EN010010 - Application by Medworth CHP Limited for an Order Granting Development Consent for the Medworth Energy from Waste Combined Heat and Power Facility (Medworth EfW CHP Facility)

Response to Section 51 advice (Examination Library Reference PD-003) and application document updates

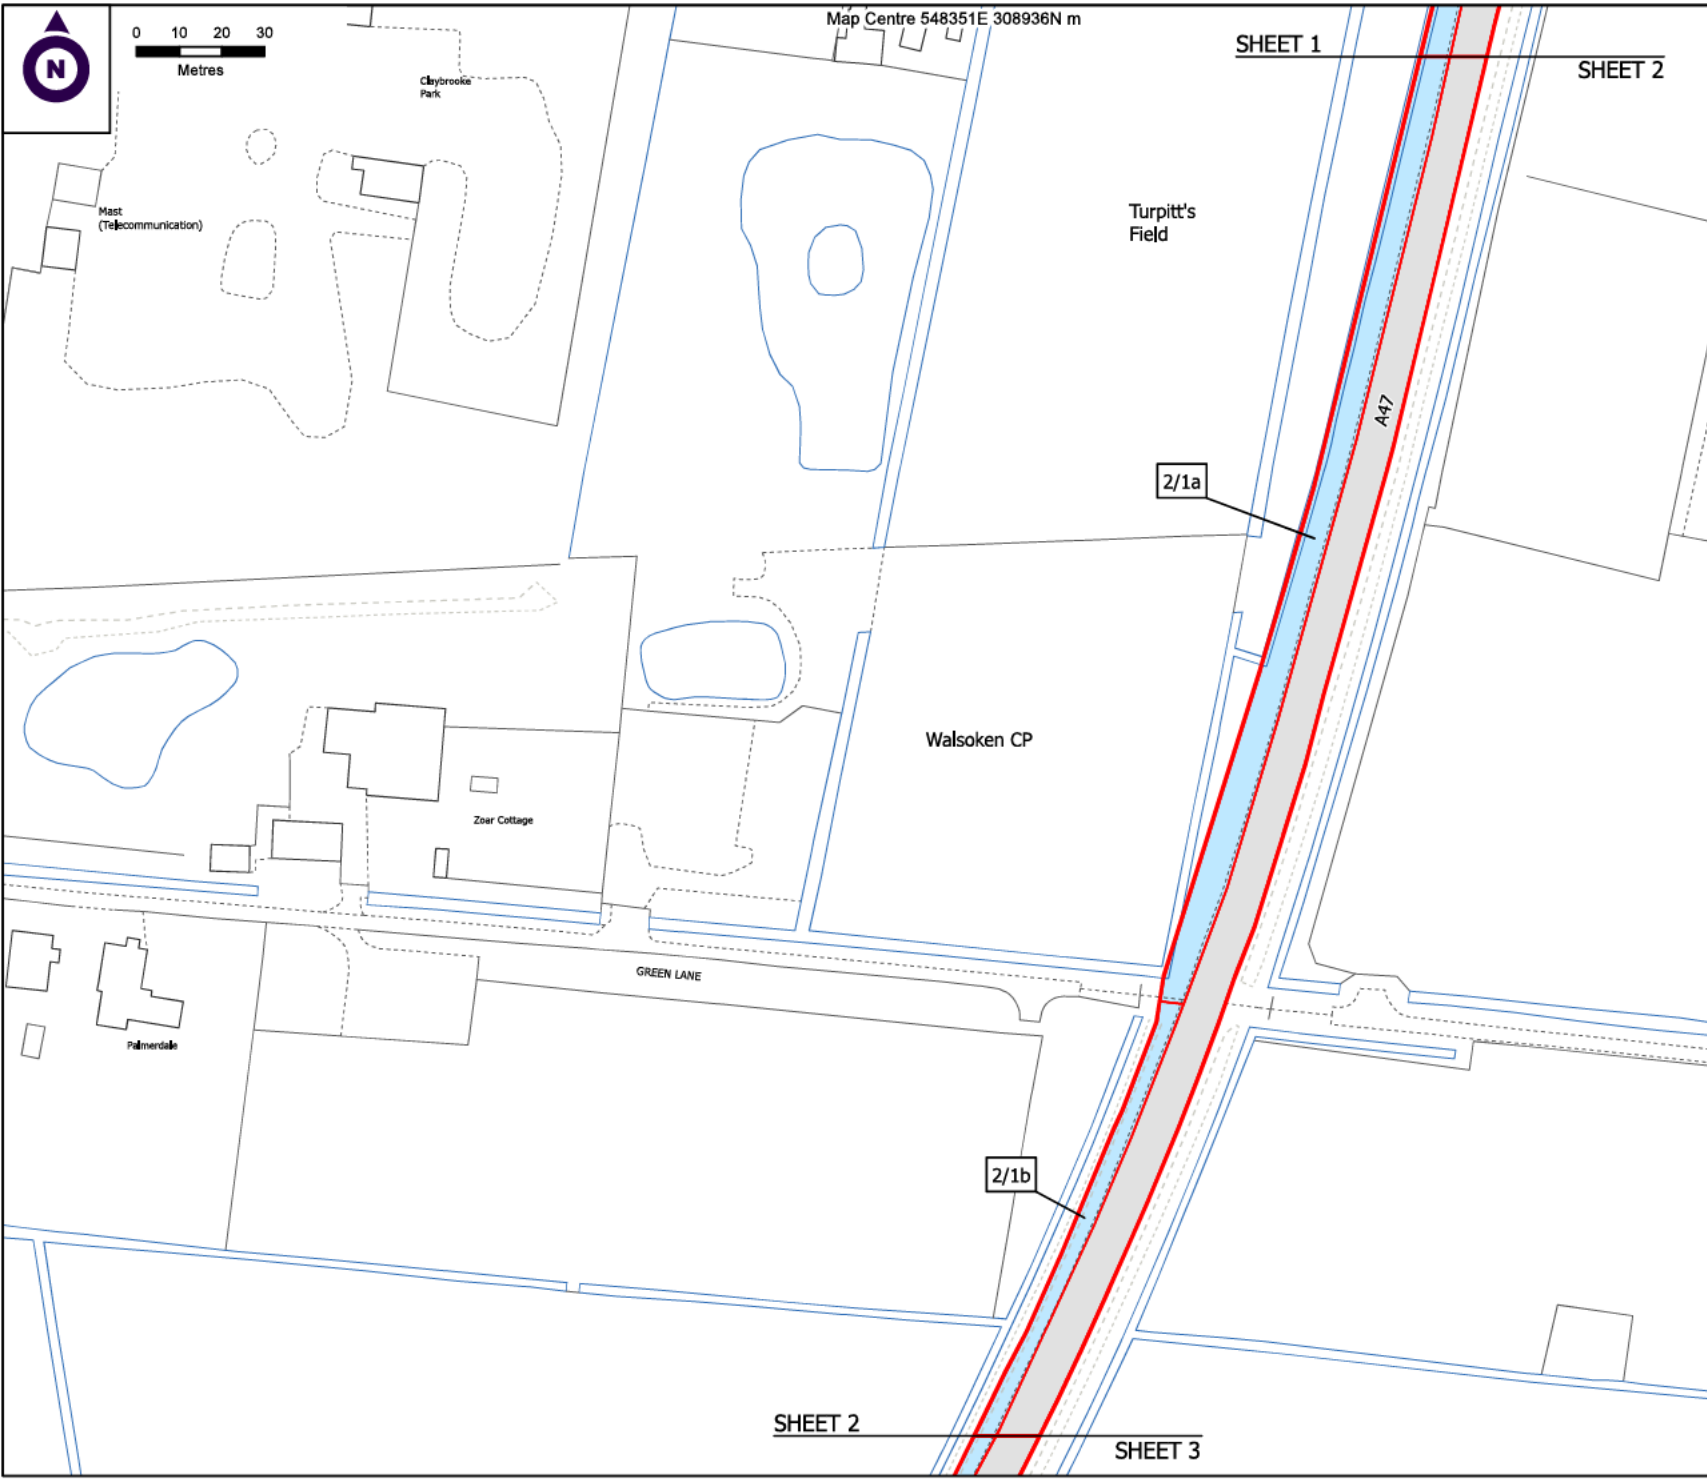
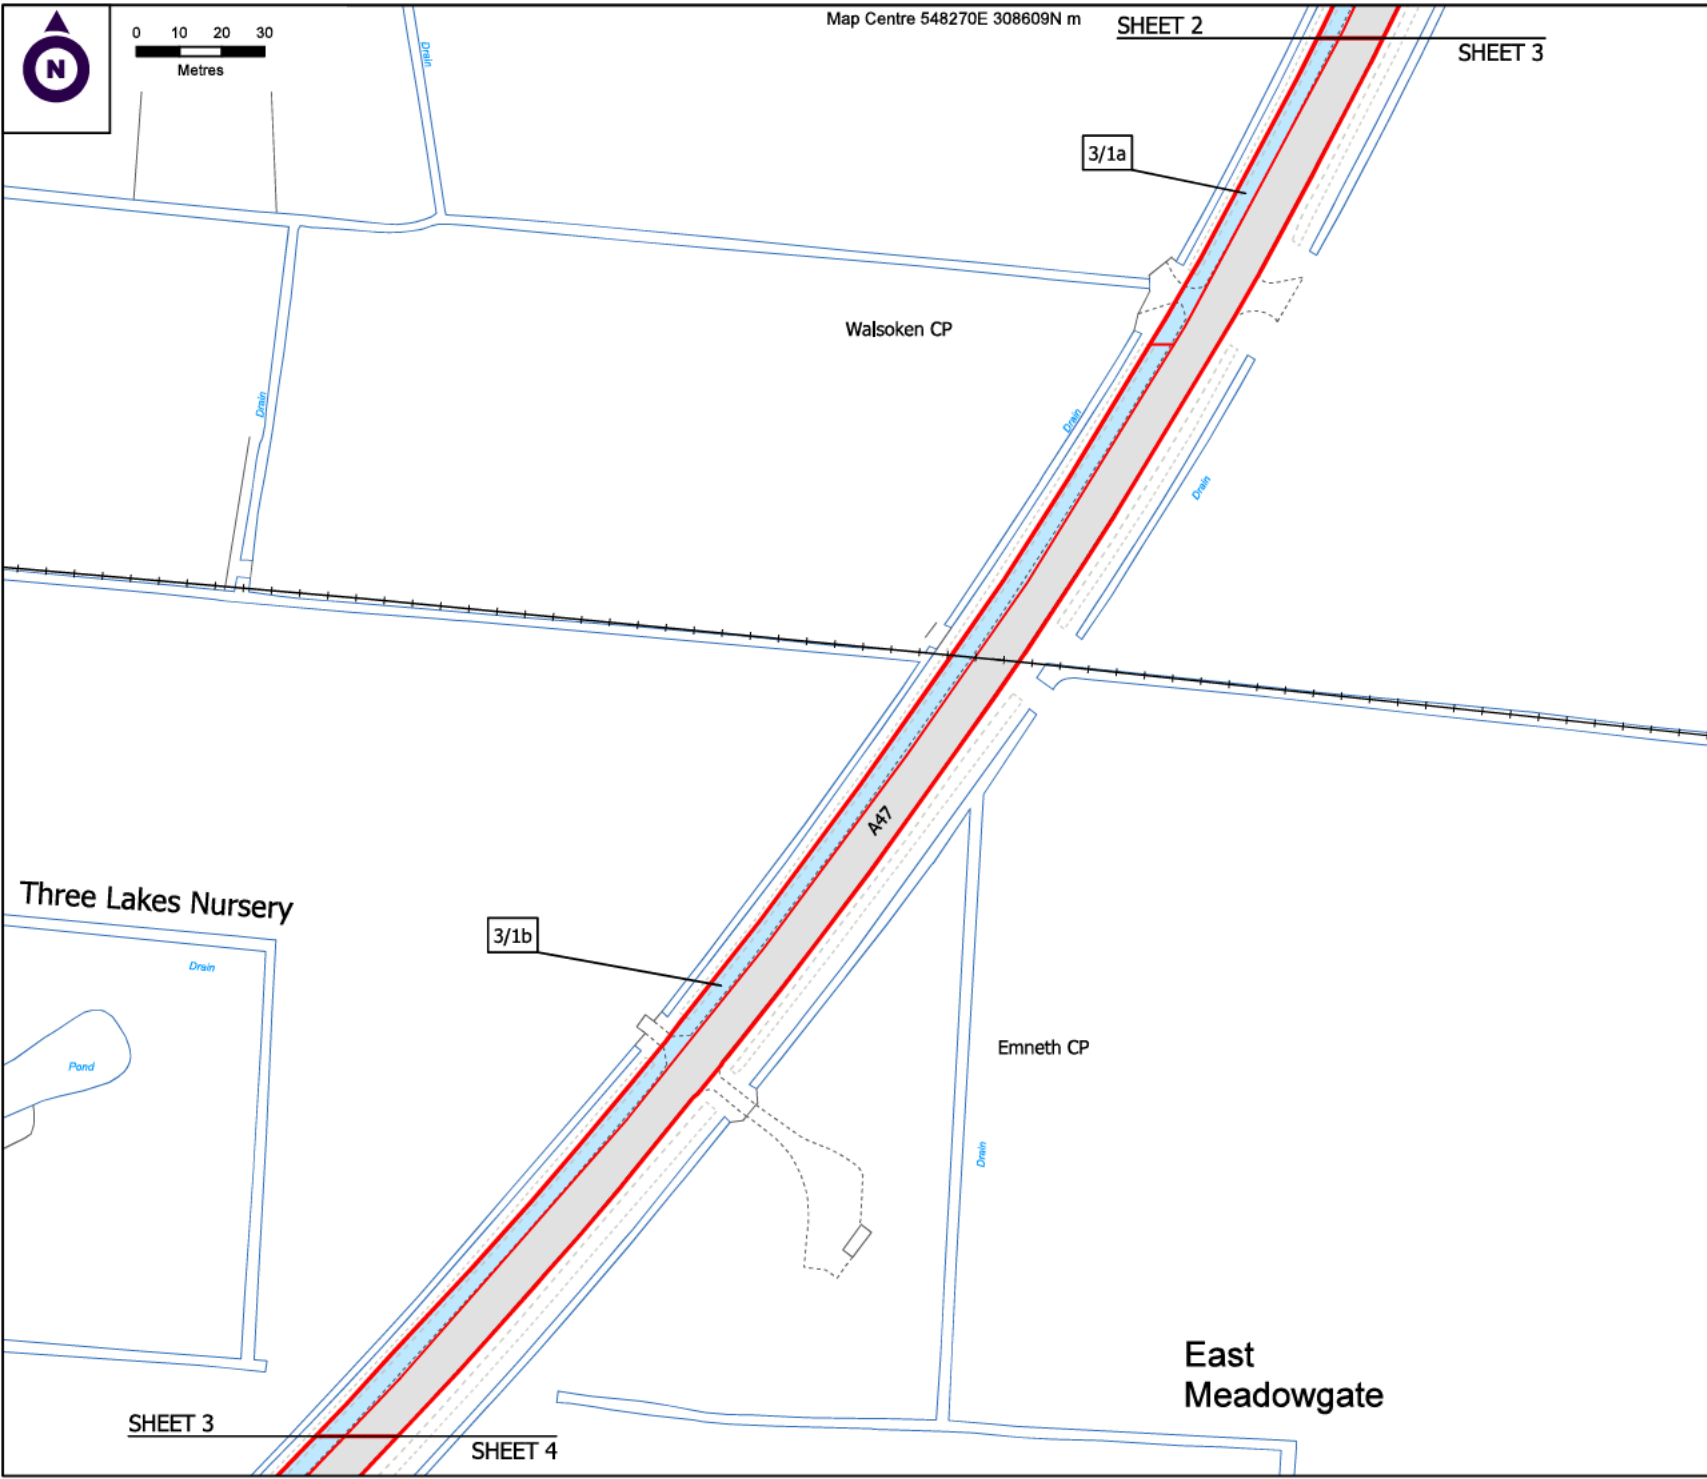
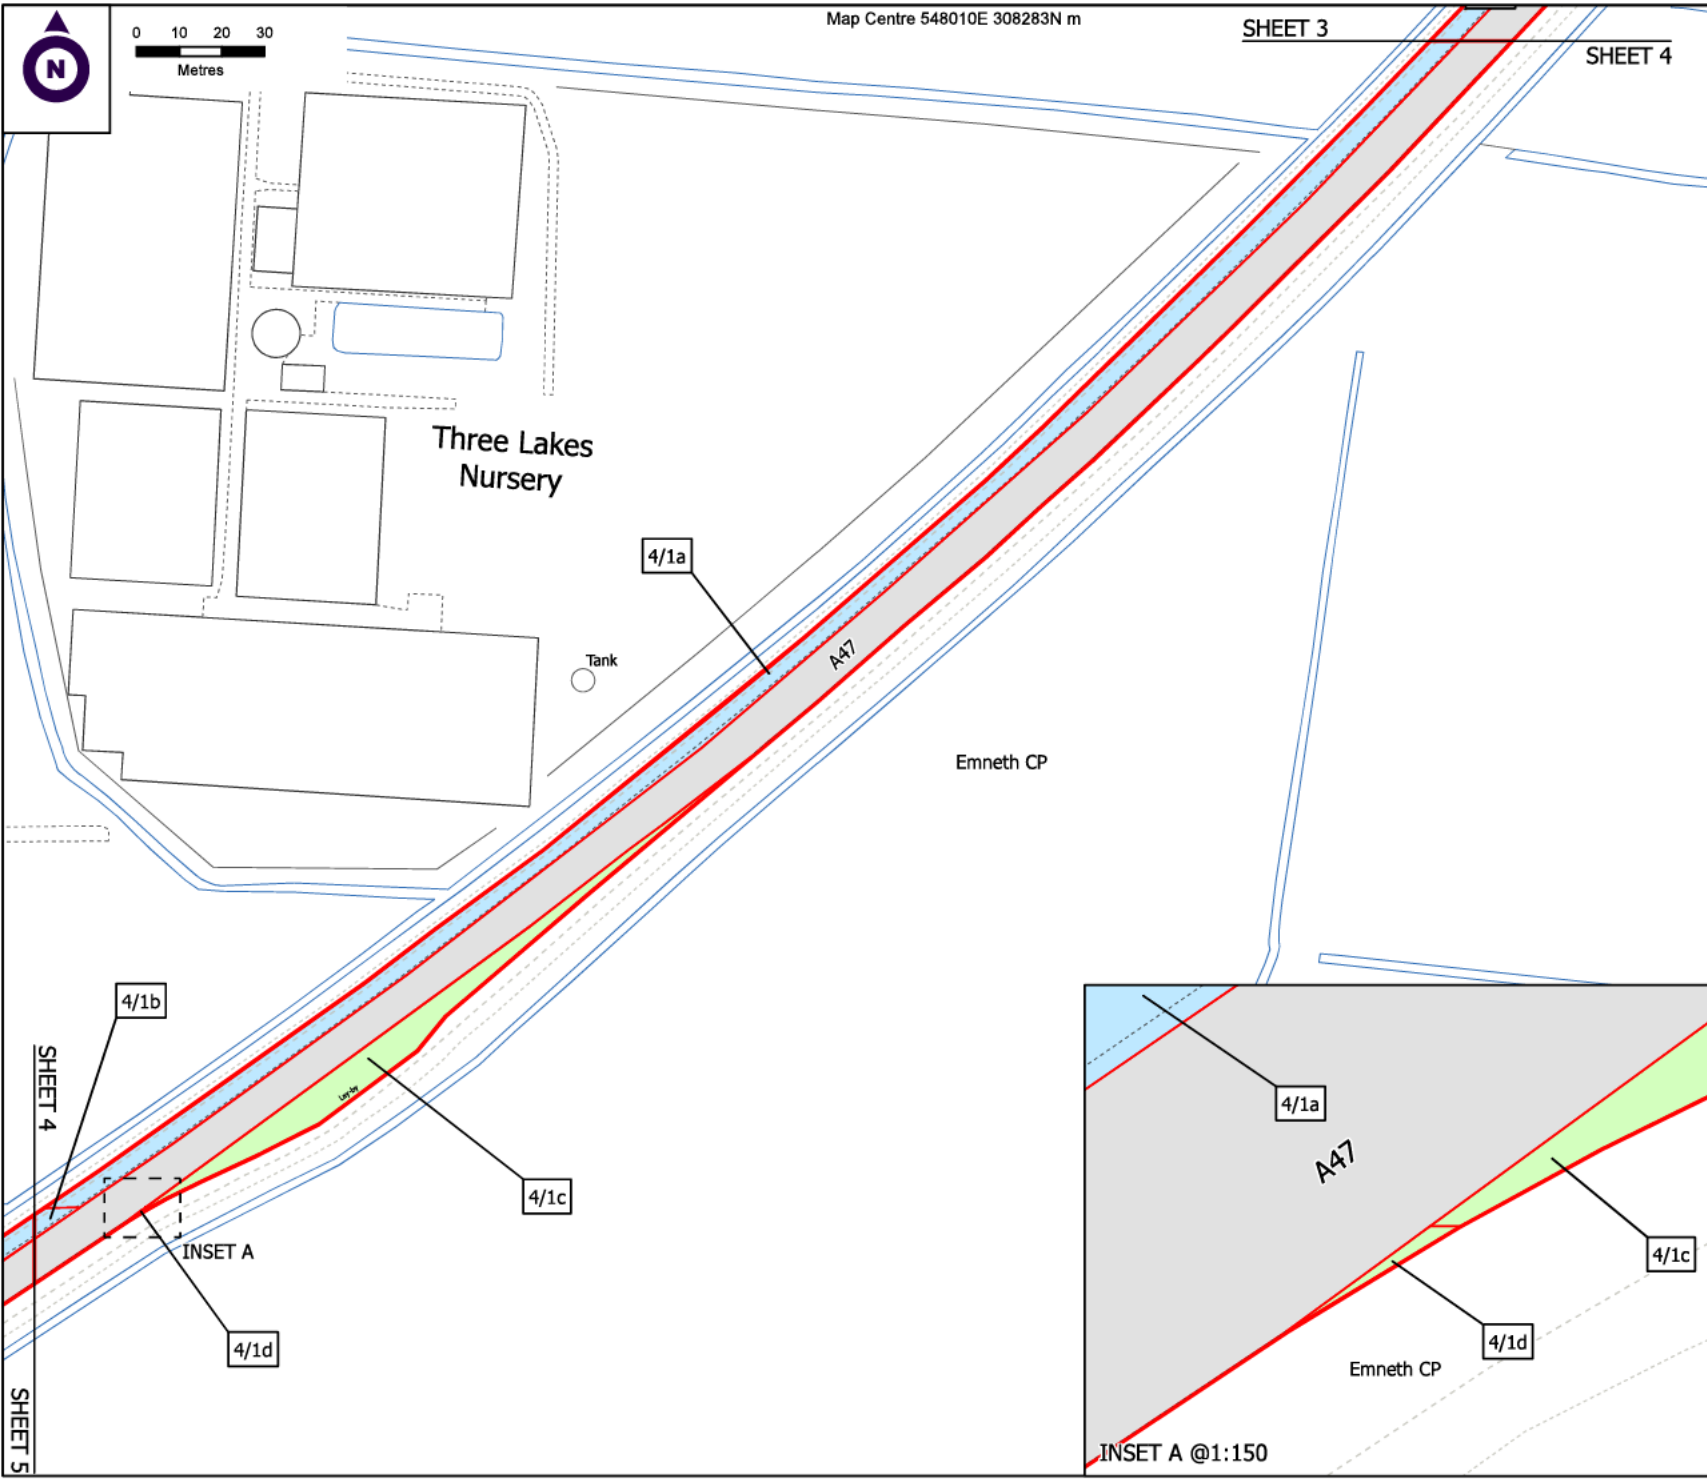
The Land Plans (**Volume 2.2**) (APP-006) have been updated so the red line demarking each plot is more visible under the cut line where the plot spans more than one sheet.
